## EA Submissions Response Apex Energy Project Application No: 07\_0103

Jointly Prepared by Apex Energy NL, EcoEngineers Pty Ltd, Biosis Research Pty Ltd and Olsen Consulting Group Pty Ltd

Apex Energy. Coal Seam Gas Exploration Drilling and Gas Monitoring Program

Figure 3.4 – Site Layout for Core Drilling Using In-Ground Fluid Pits

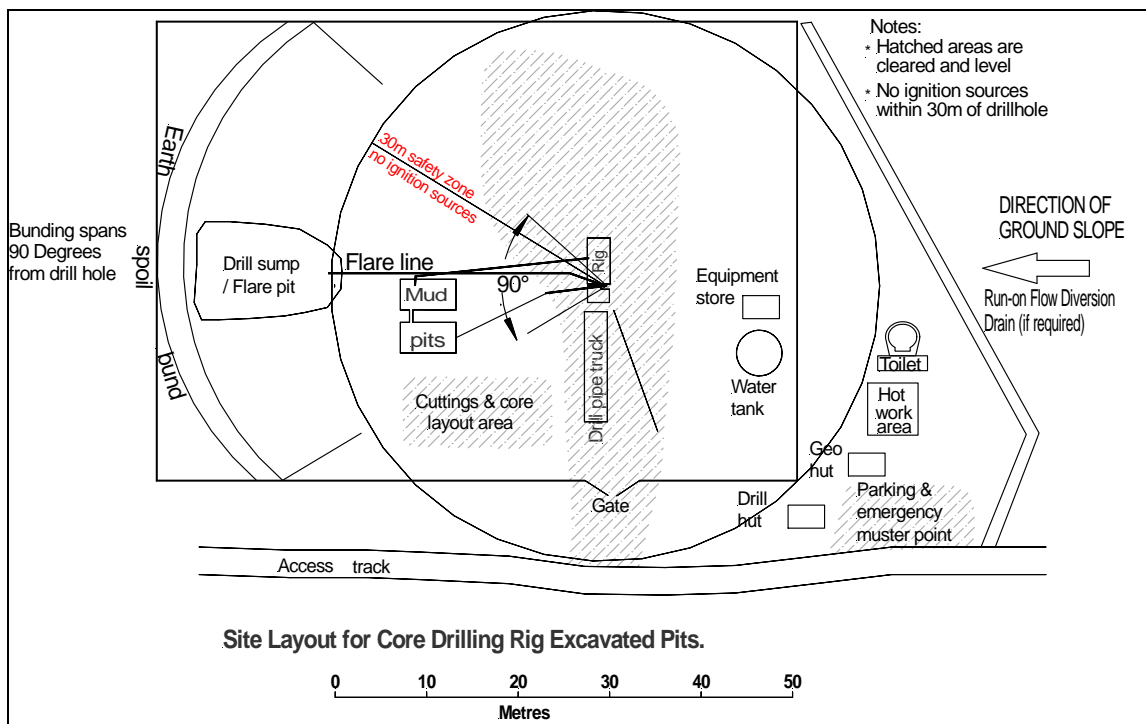
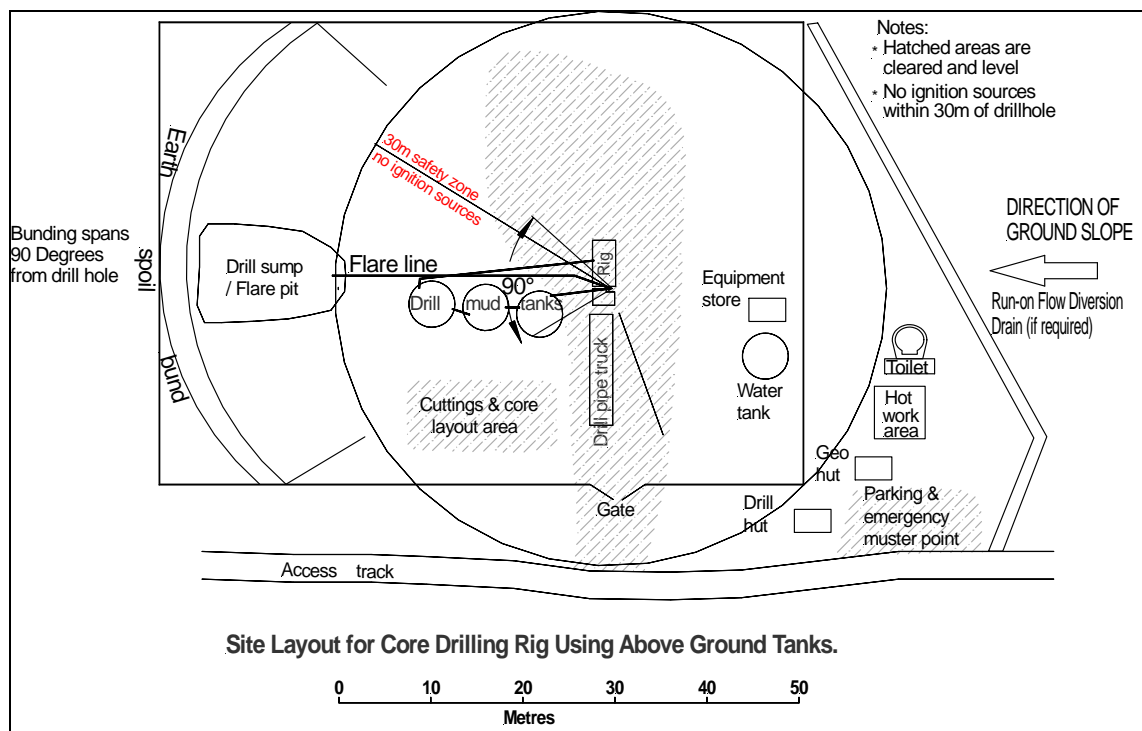
Sydney	5.2 At sites AI10, AI14, AI18	In-ground sumps are standard (and demonstrably successful) features of drilling activity in catchment areas. Surface tanks

Submitter	Submission Item	Draft Response
<b>Catchment Authority.</b>	and A116, above ground water tanks must be used rather than in-ground sumps to avoid/minimise ground disturbance, soil erosion and sediment runoff.	<p>require increased vehicle activity for maintenance and can require similar site disturbance as in-ground tanks.</p> <p>Apex will construct both clean run-on diversion drain or bund wall and a runoff detention bund wall on the site. These will minimize run-on and contain runoff any minor drilling fluid spillage.</p> <p>It is possible to line inground drilling sumps with plastic liners if demanded by SCA.</p> <p>It is noted that at the end of drilling, all spent drilling fluid would be pumped out of the sumps into tankers and transported off site, (to a licensed waste disposal facility).</p> <p>Plastic liners may mitigate drainage through the sides and bottoms of sump. However, typically drilling sumps are not lined. Because the drilling fluid invariably contains comminuted rock fines and clays which form a low permeability coating on the sumps.</p> <p>Therefore in combination with a run-on diversion drain / runoff detention bund on low side of the drill site and the ability to implement protective plastic covers for deployment during large storm events this would normally be a reasonable alternative to sump-less drilling (which uses tanks or tankers to contain recirculating drilling fluid).</p> <p>Cuttings and drilling fluid may also typically be left in the pits. When the fluids dry up, the sumps are normally back filled with soil over the top and respread. Typically vegetation covers them quickly due to the fertilizing effects of starch and potassium in the mud residue left in the pits.</p> <p>Apex recommend that subject to consultation with SCA, in-ground sumps be permitted to be used.</p>
